Appeal Decision

Appeal Ref: APP/R5510/D/15/3134462

16 Seaton Road, Hayes, Middlesex UB3 1NS

- The appeal is made under section 78 of the Town and Country Planning Act 1990 against a refusal to grant planning permission.
 - The appeal is made by Mrs Jasbinder Kooner against the decision of the Council of the London Borough of Hillingdon.
 - The application Ref 5090/APP/2015/1595 was refused by notice dated 24 June 2015.
 - The development proposed is a part first floor rear extension.
-

SCALE: 1:50 DATE: APR. 2015
2015/116/02

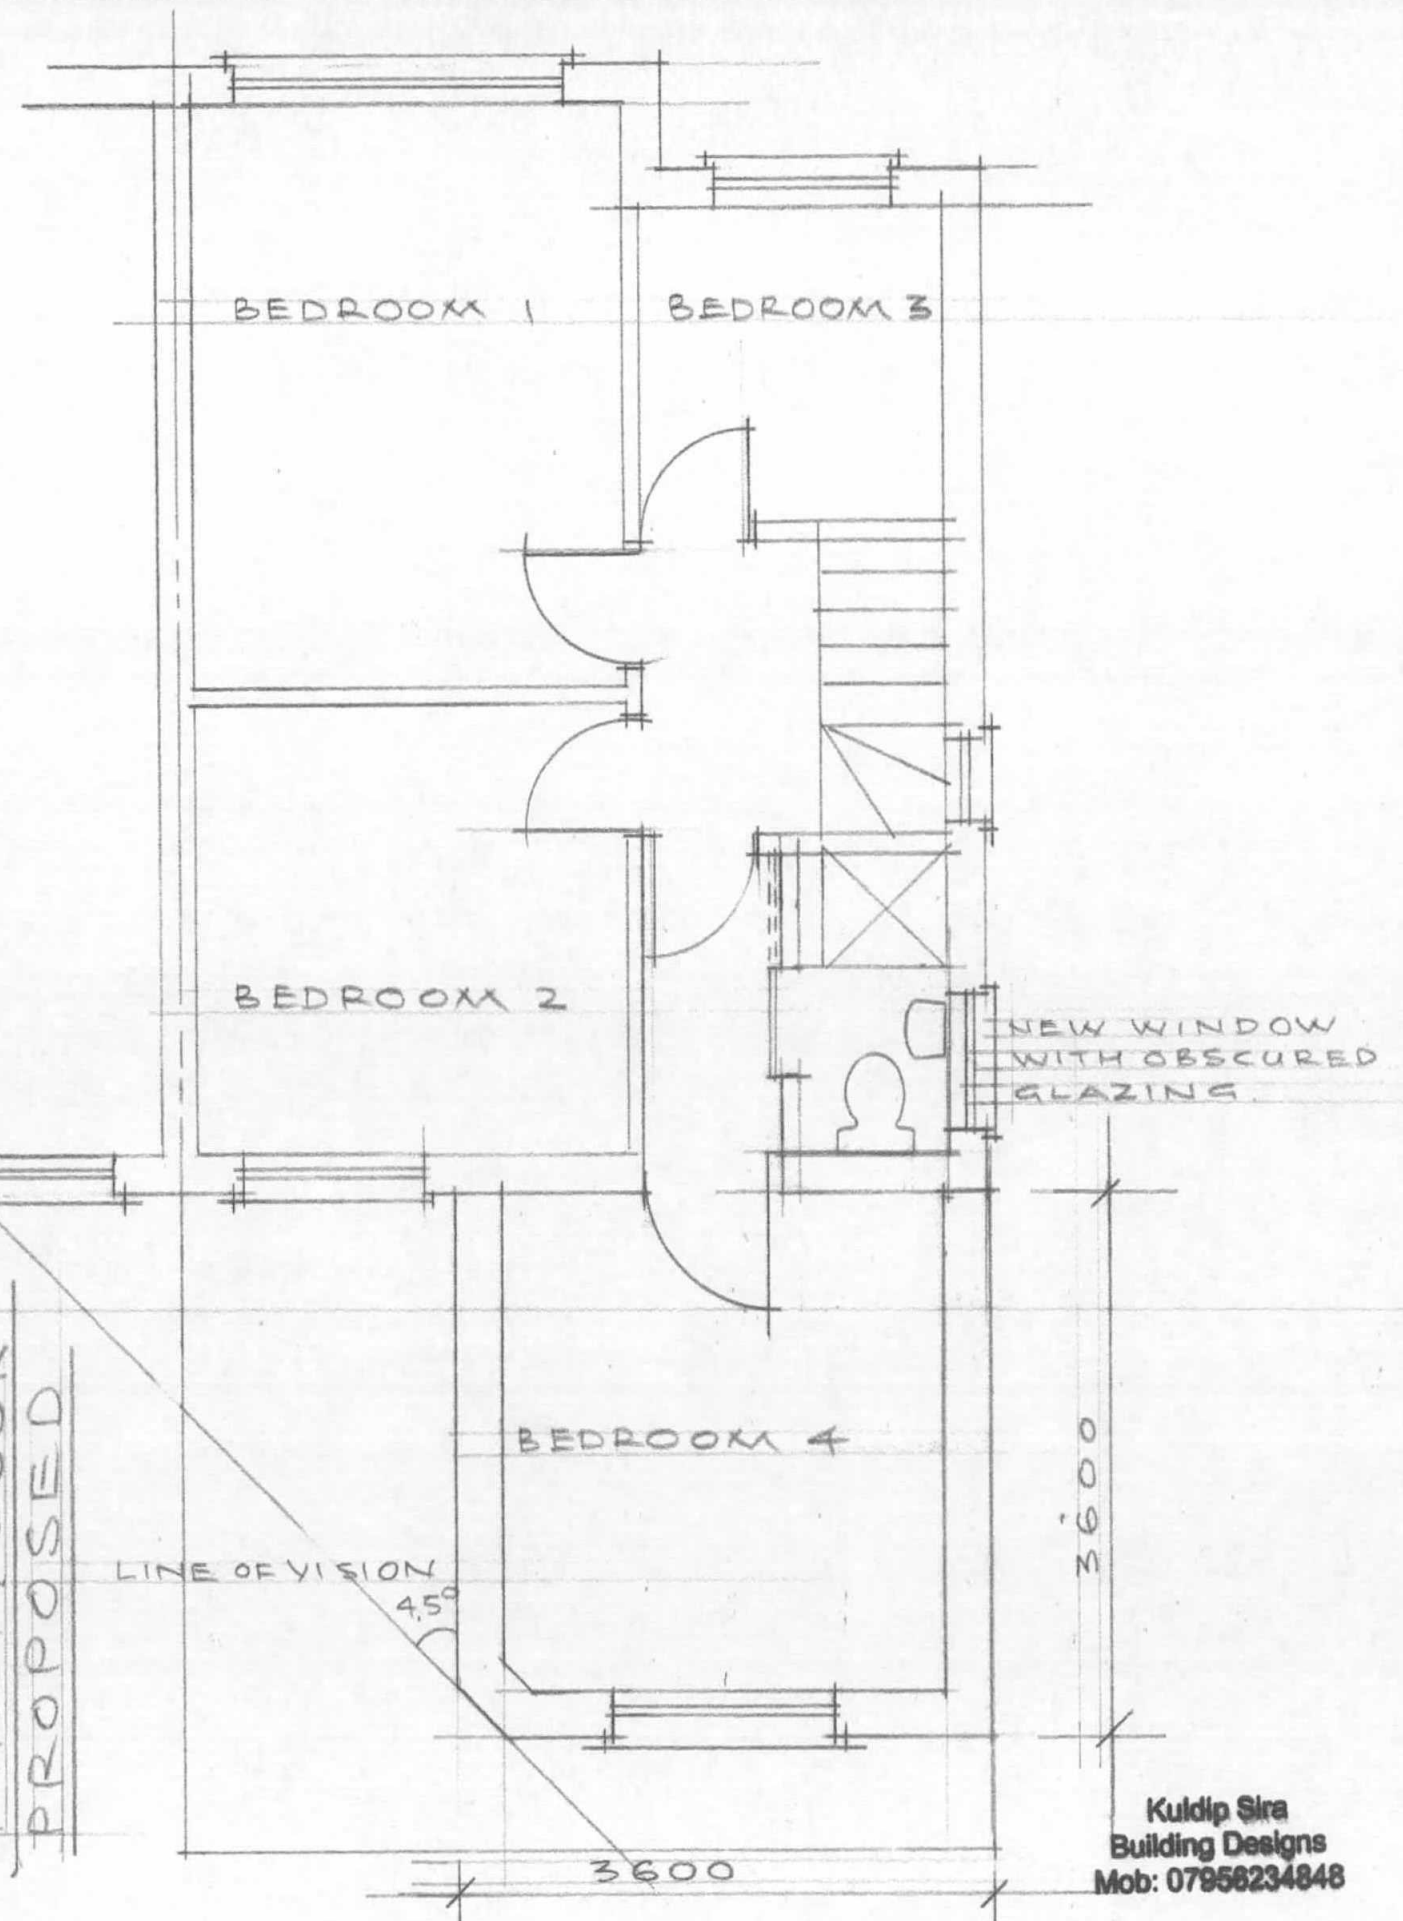
5. The appeal dwelling has been extended to include a rear dormer on a loft conversion, together with a side gable and a rear single-storey projection. The proposal includes a first floor rear extension over part of the existing single-storey rear projection. It would have a depth of 3.6 metres and a width of 3.6 metres. It would be set some 1.6 metres below the existing main ridgeline.

SCALE: 1:100 DATE: APR. 15
2015/116/04

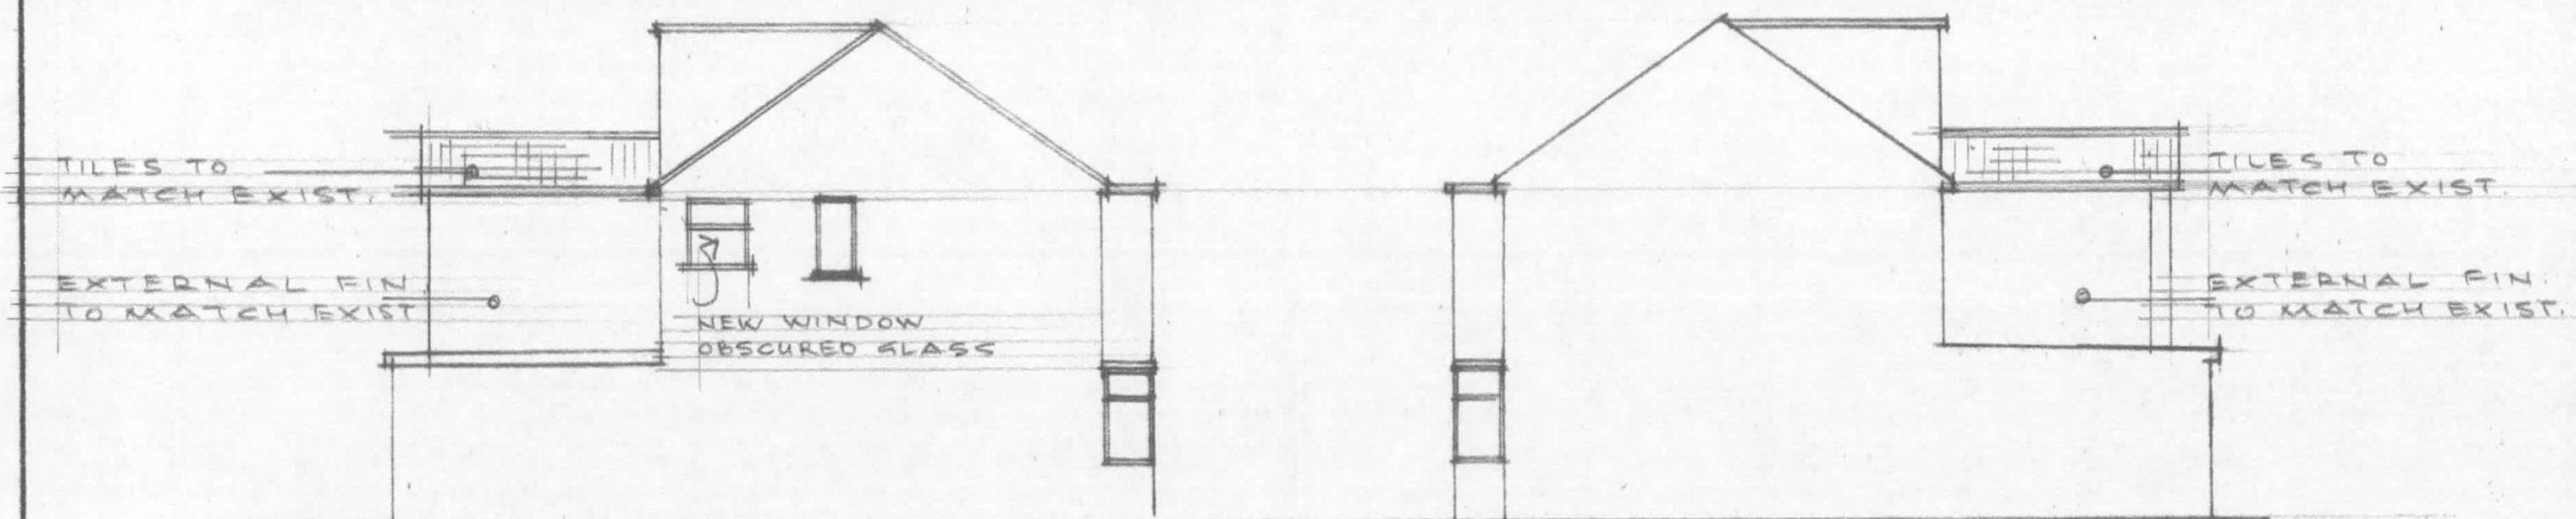
6. The rear of the original dwelling is currently dominated by the existing rear dormer and the single-storey flat roof rear extension. From my observations, due to the set down, scale and depth of the proposed extension, I consider it would appear as subservient addition and I do not consider that the cumulative additions would significantly adversely affect the scale, form, architectural composition and proportions of the original building. Thus, for the same reasons, I consider that the proposal would not adversely affect the appearance of the surrounding rear garden area. Therefore, the proposal would be in accordance with the above Local Plan policies.
